Application No: BE/149/20/PL
Site Address: 339 Chichester Road Bersted PO21 5AN
Description of works: Replacement of blockwork boundary wall with fence & new vehicular access. This site is in CIL Zone 4 (Zero Rated) as other development.

Thank you for your internet representation made on 11th January 2021 which has been recorded as an objection with the comments as follows:

SITE PLAN

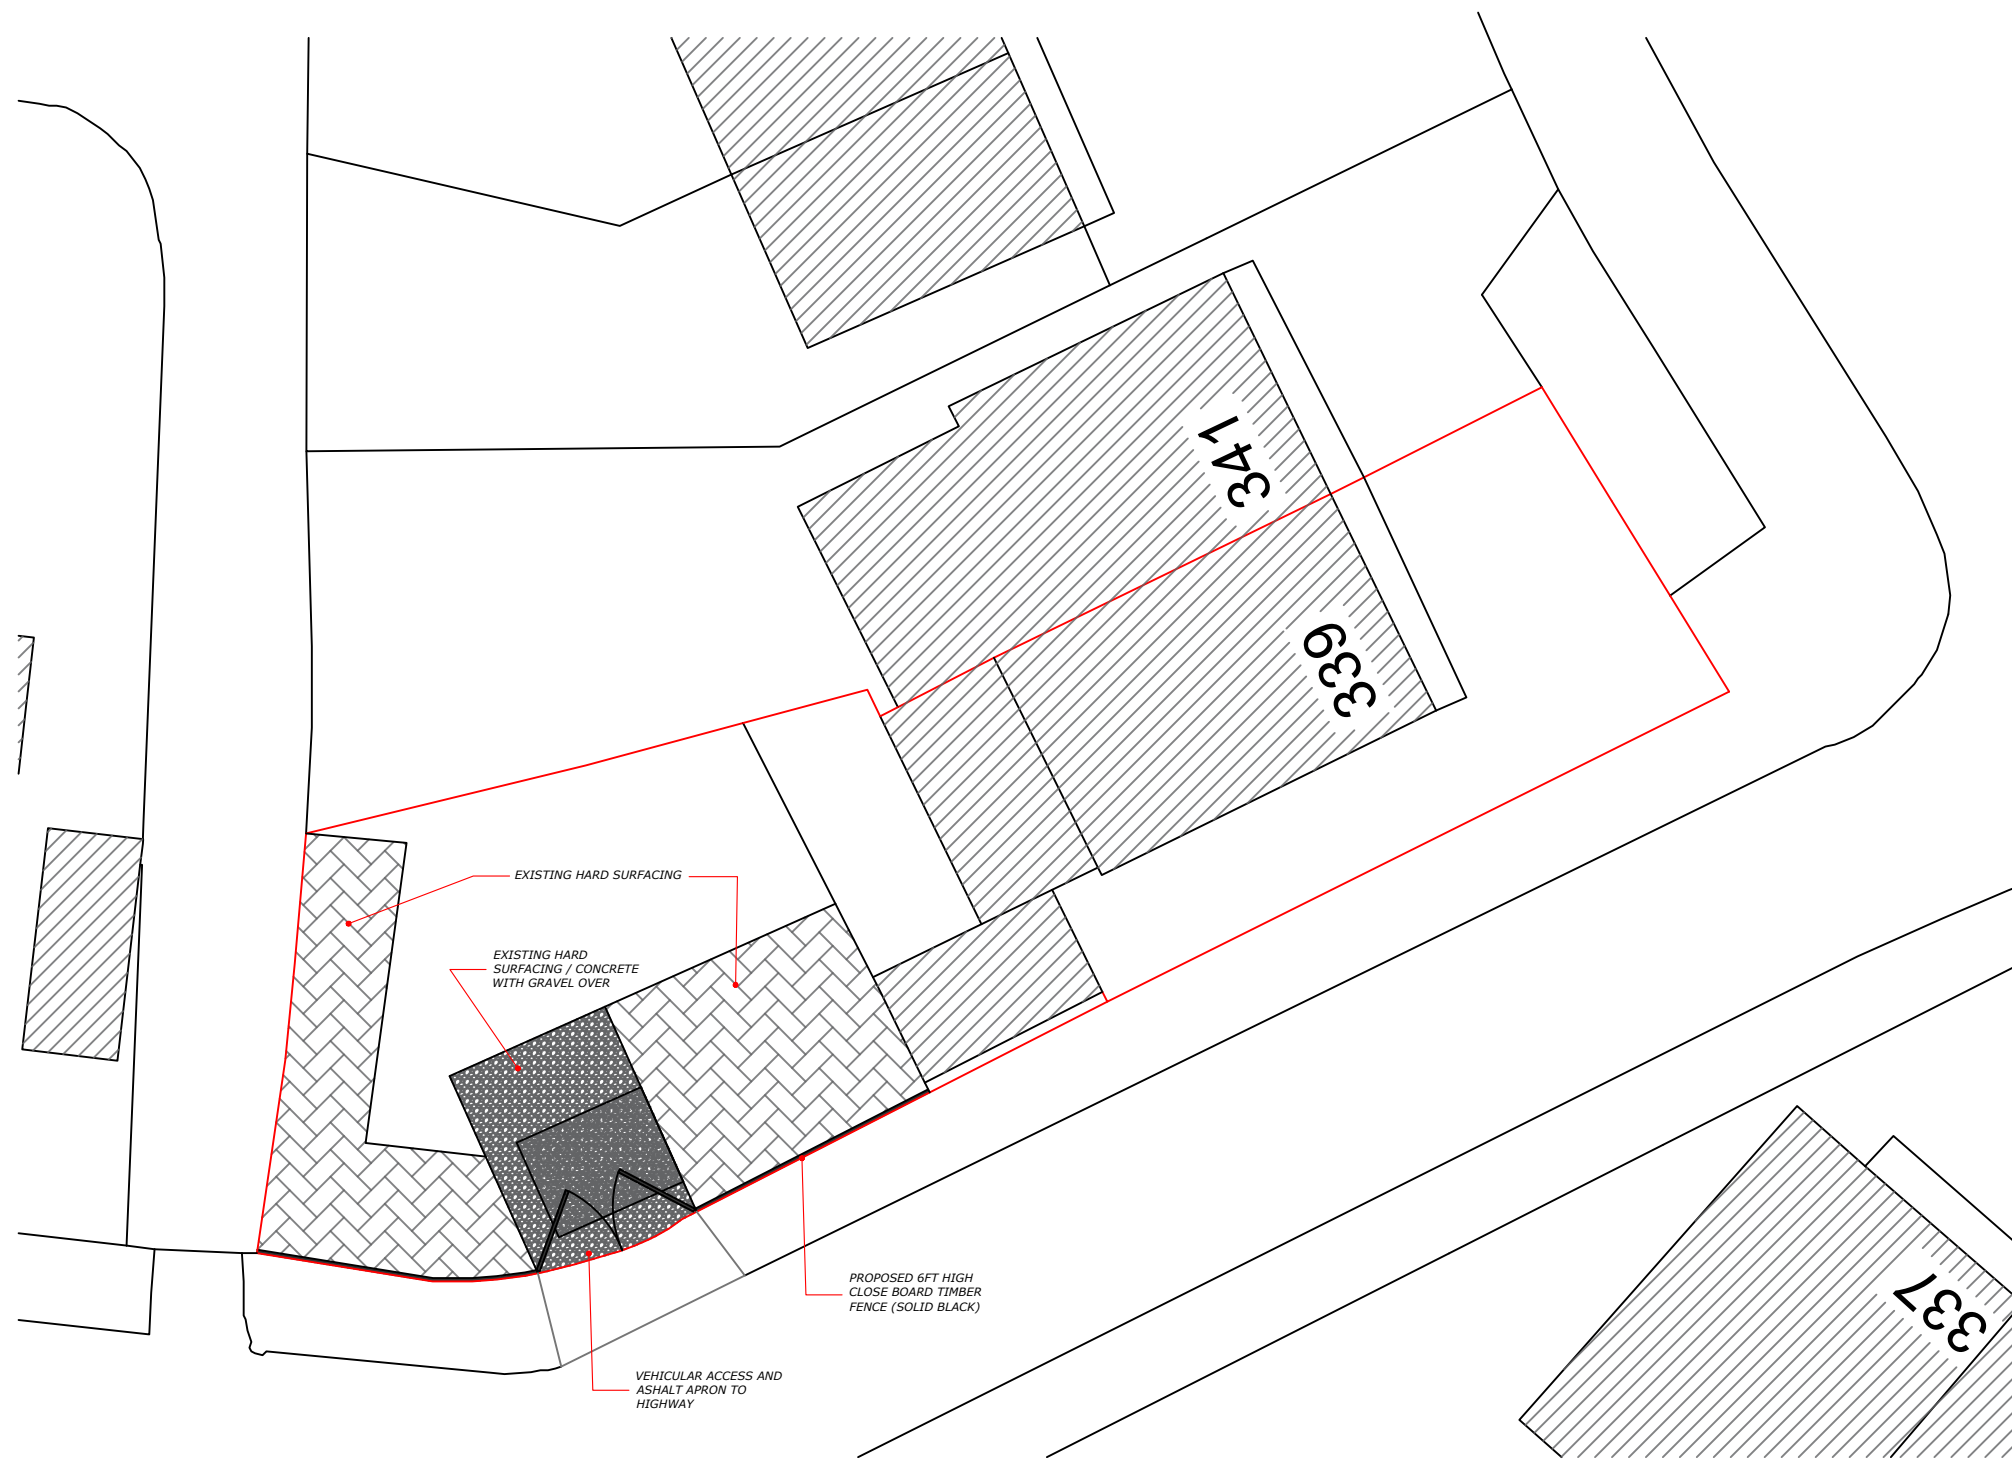
WE have a major objection to this developement mainly on the grounds of safety. The area is already busy with residents struggling to park. The addition of another access, especially commercial, would increase further the traffic in the area. The proposed entrance is on a bend opposite a lane which would make it basically a crossroads on a bend. With residents parking adjacent, opposite and alongside the proposed entrance the street becomes single lane and with vans entering and exiting onto Bedford Avenue on the bend, between parked vehicles it becomes hazardous due to all vehicles struggling with the ability to see vehicle movement from all directions.
